# ENG-SF22023-R2-CDs.pdf Markup Summary

**INTERSECTION DETAIL**

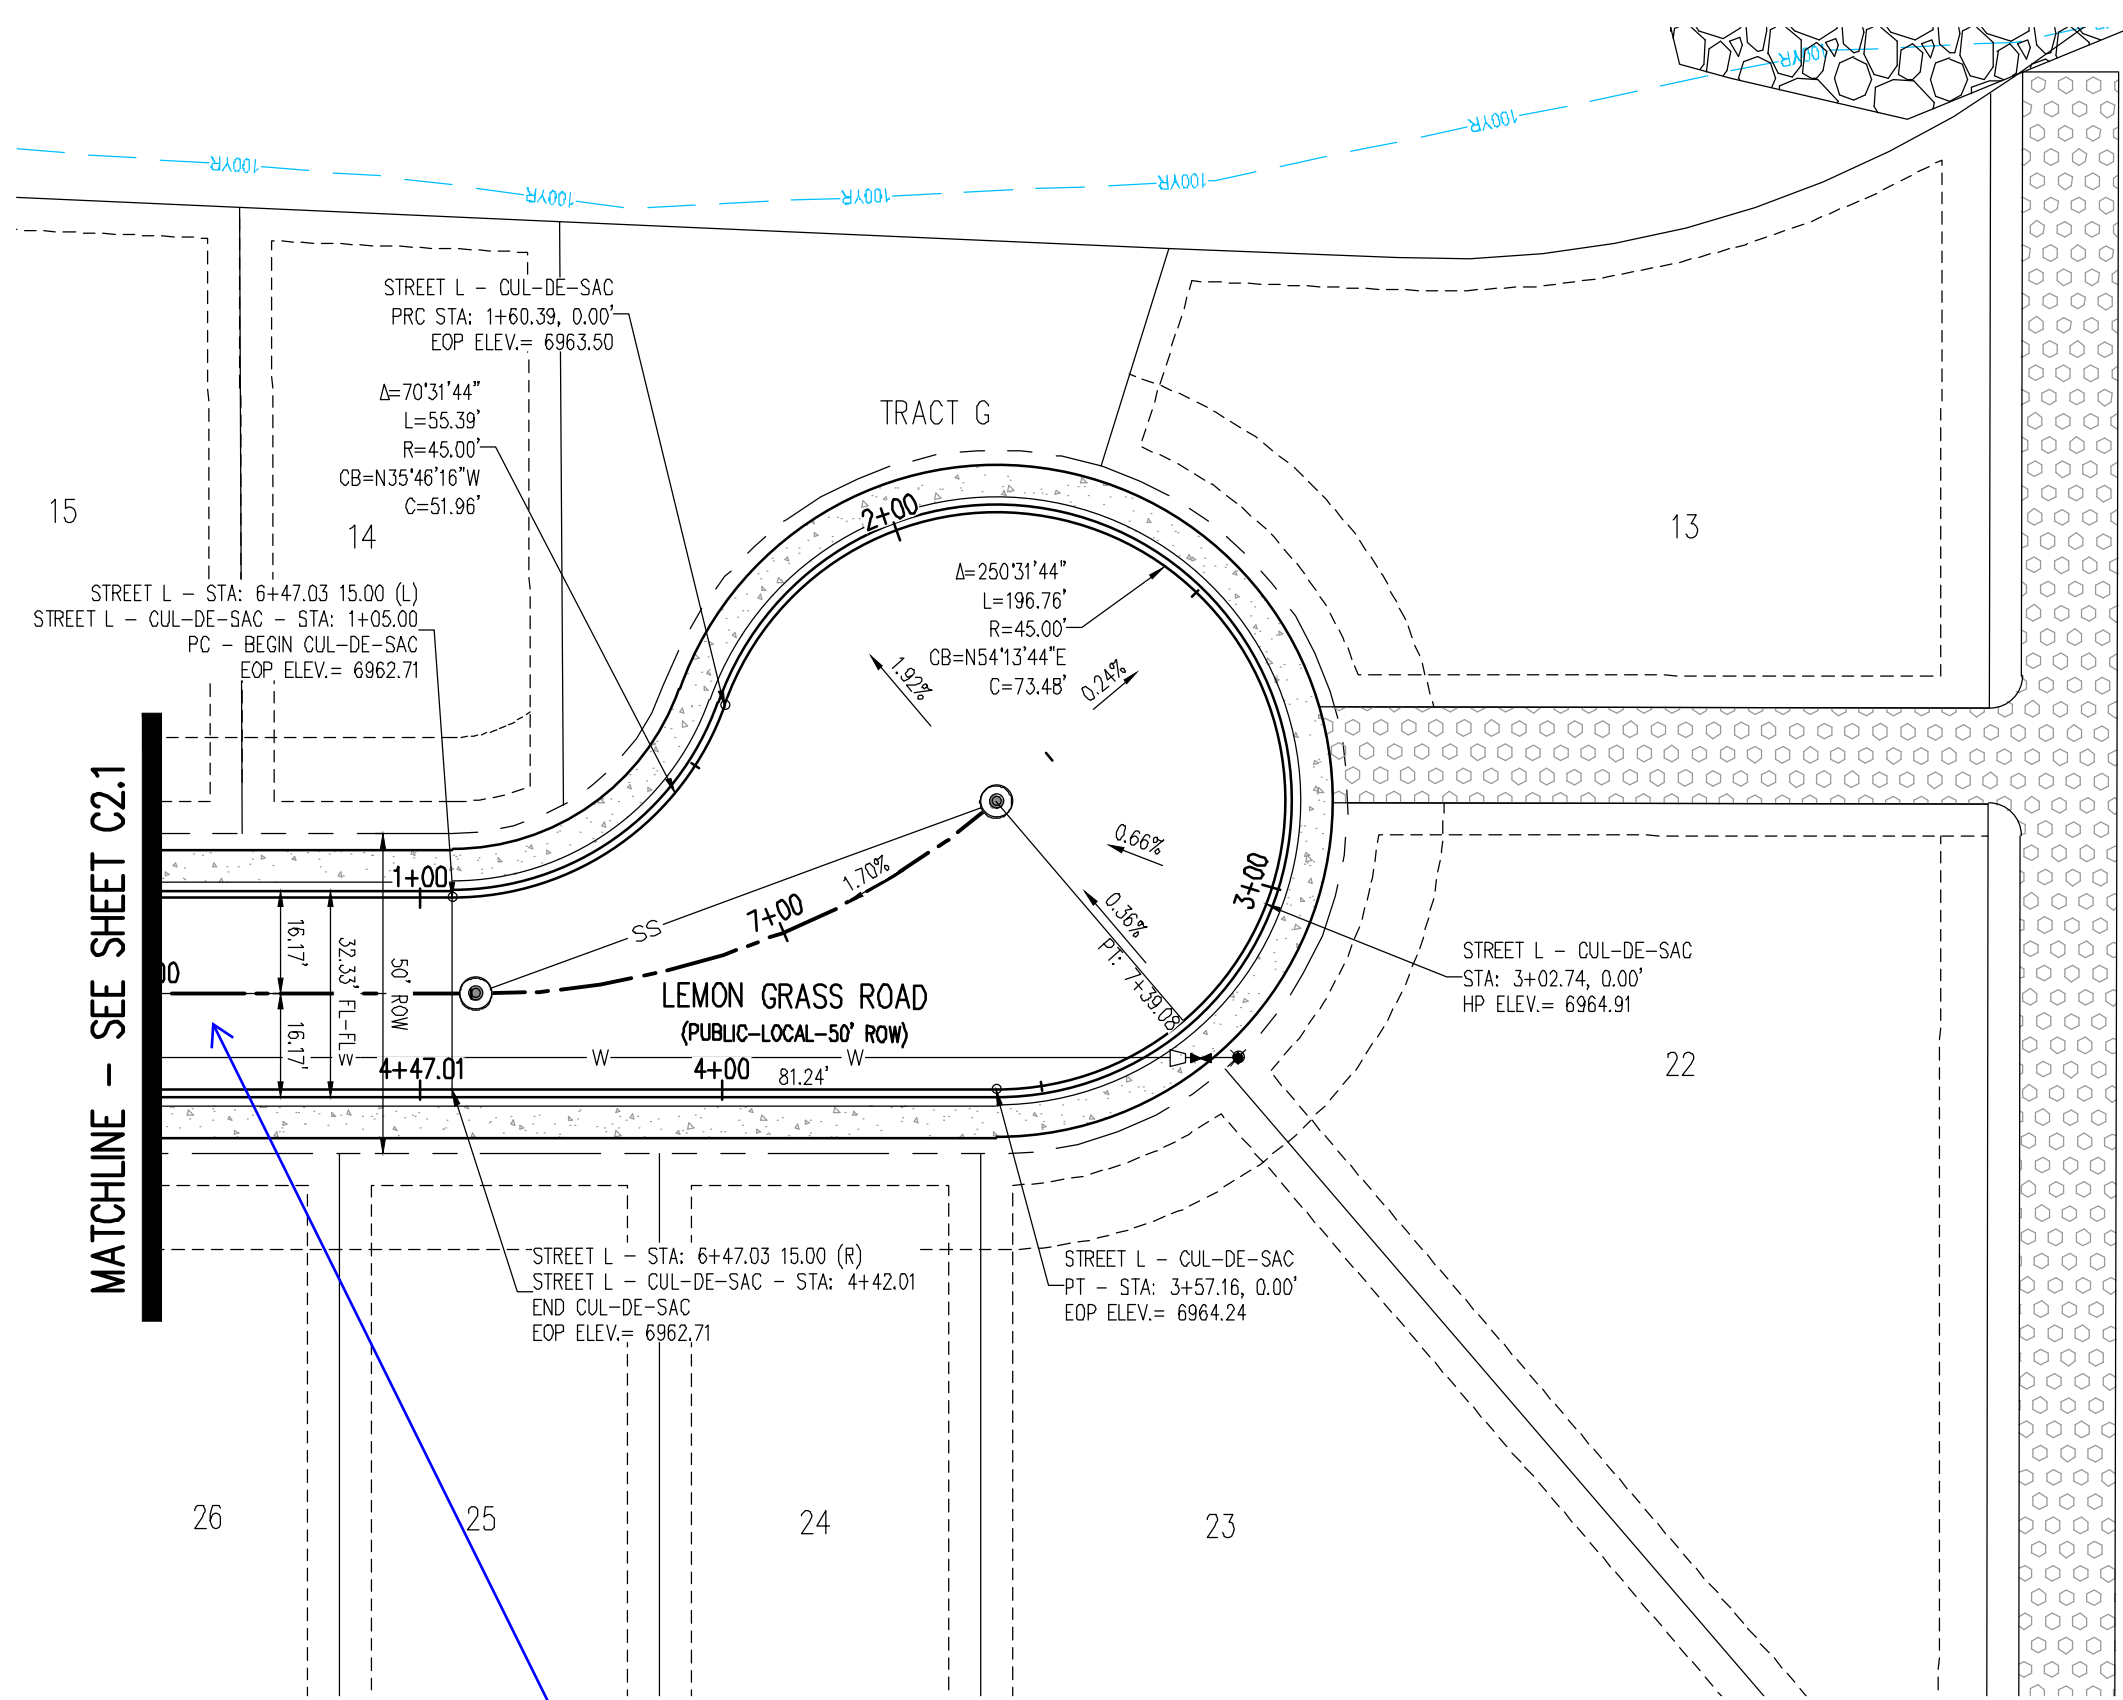
Can't this be made steeper to minimize vertical curve issues?

Label sight distance lines and easements

Adjust sight distance line?

Revise lot lines to bevel behind sidewalks

See deviation request comments

Label features to be removed

LEMON GRASS DR. (STREET L) STA: 6+00 - 7+94.08  
 SCALE: H: 1"=30' V: 1"=3'

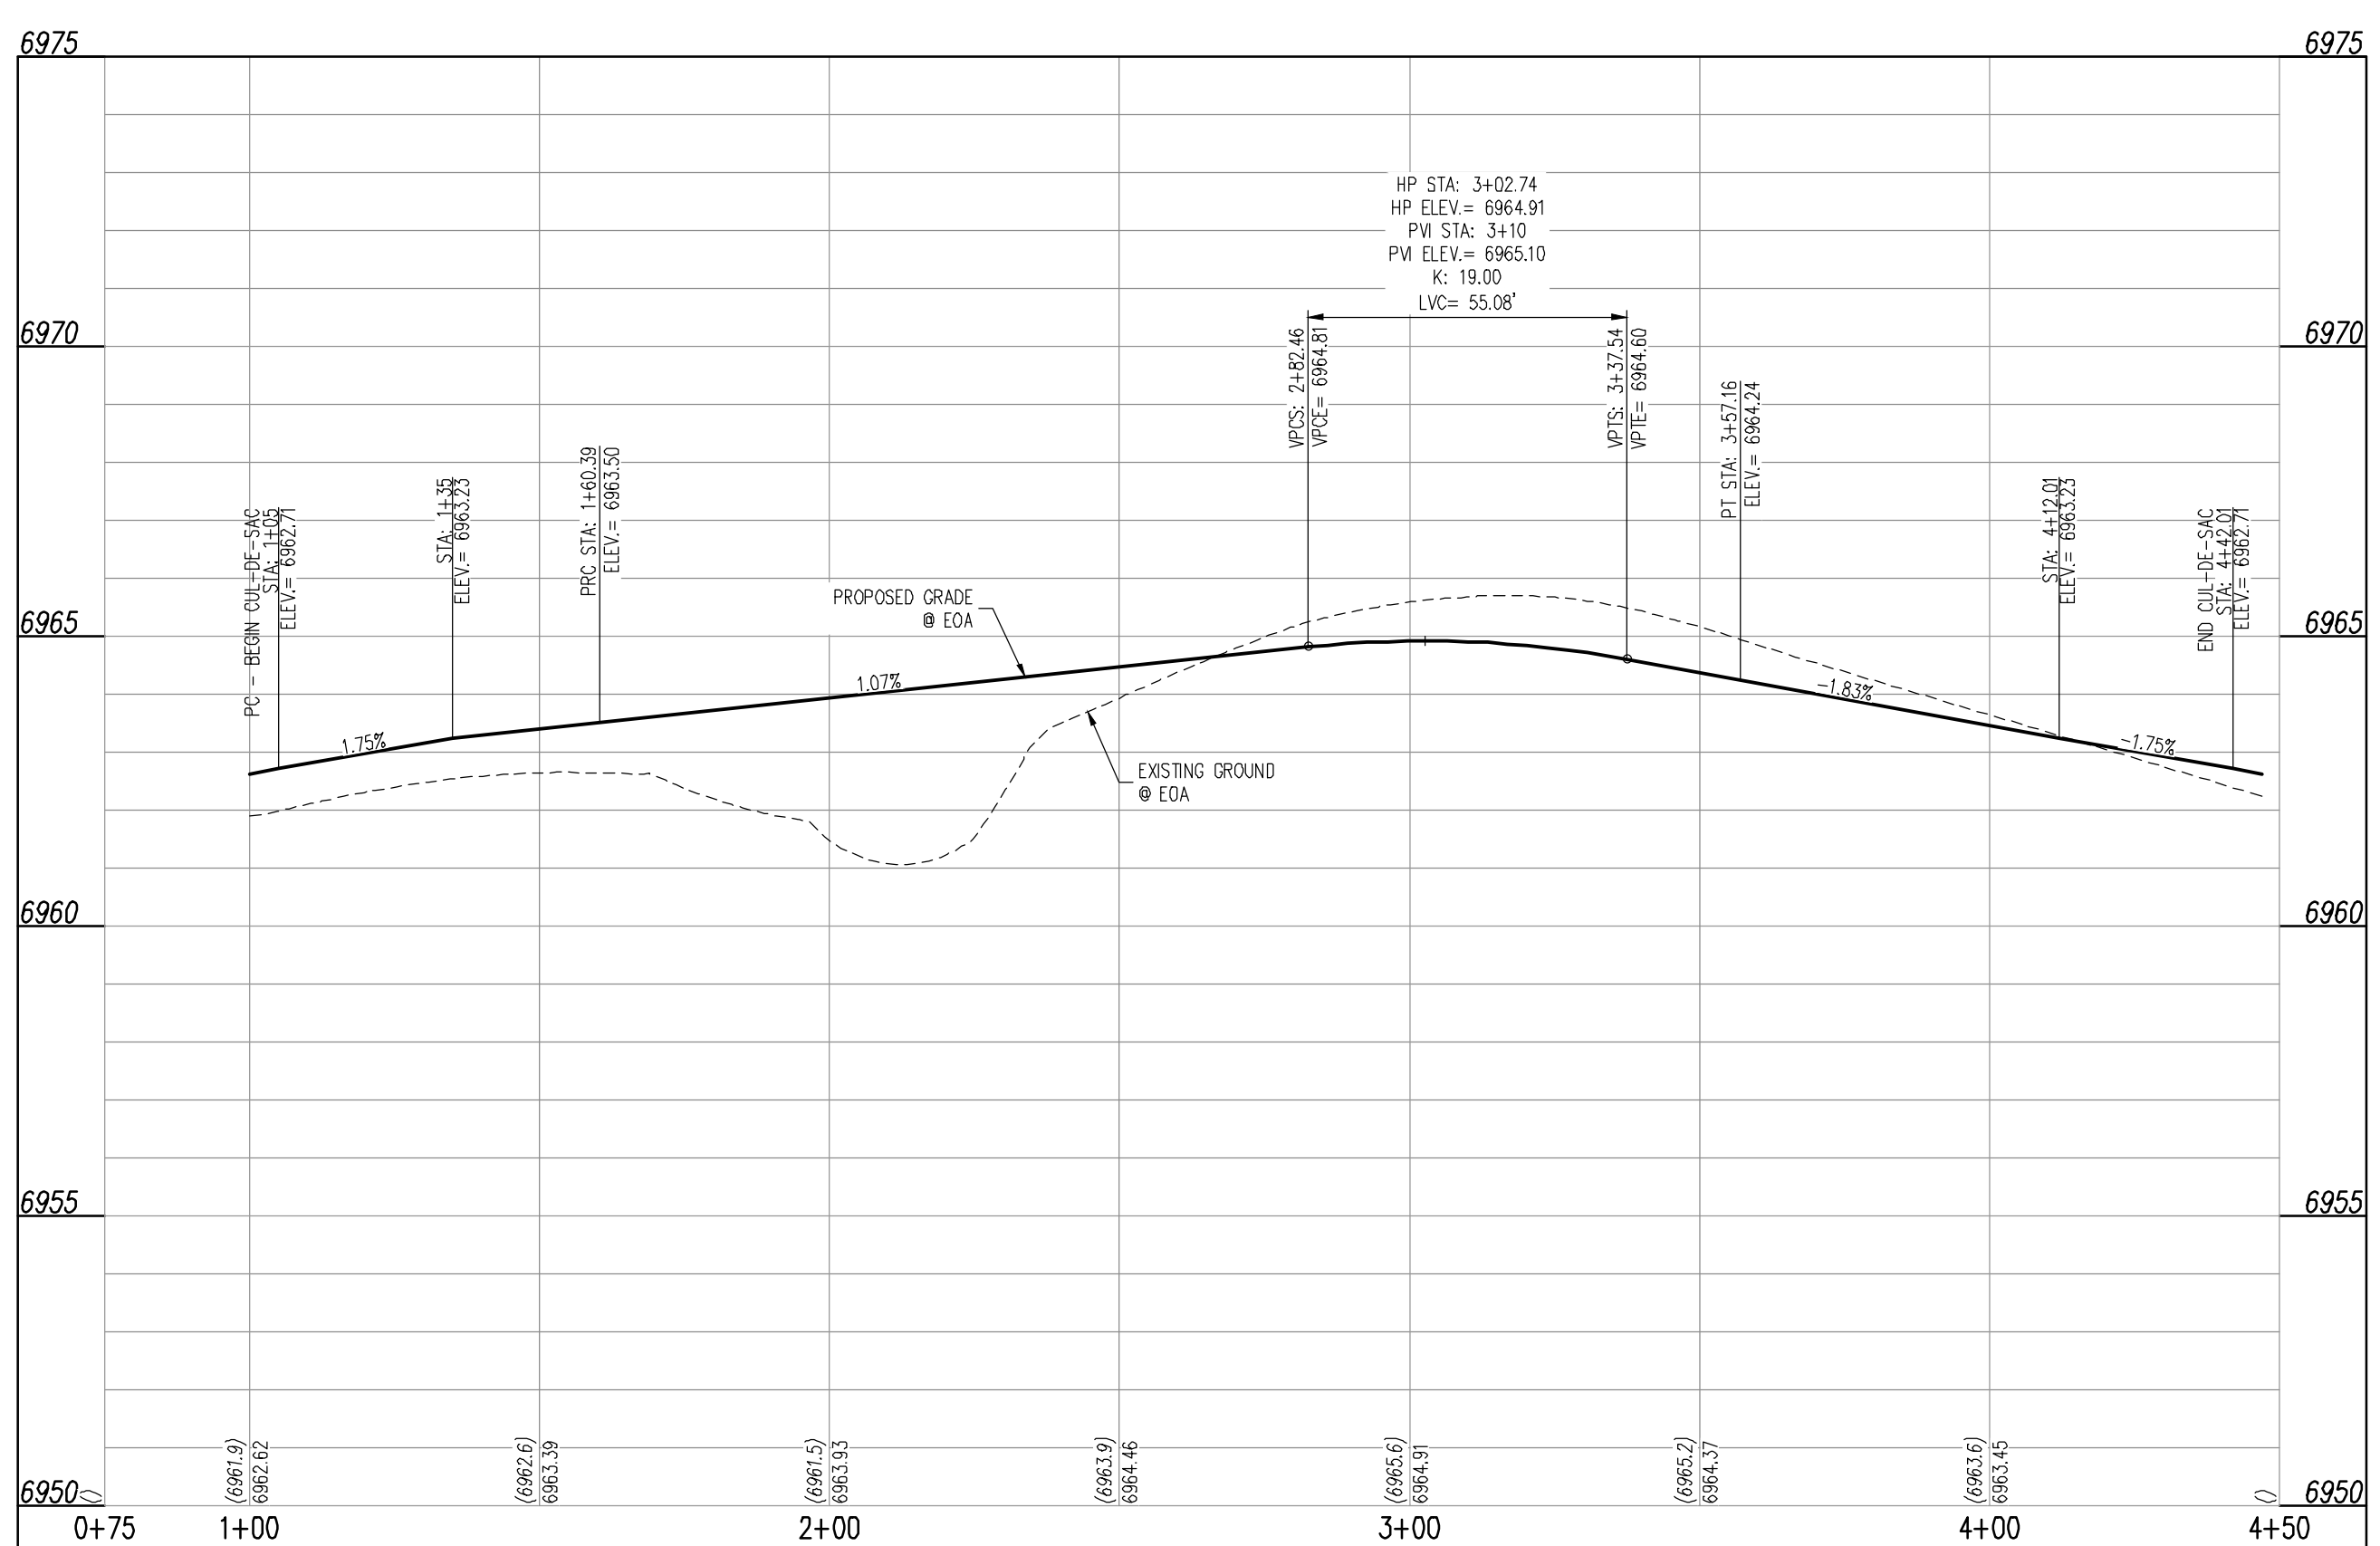
Can this be pulled down to mitigate issues on Lemon Grass?

Label the existing grade

Label the existing grade
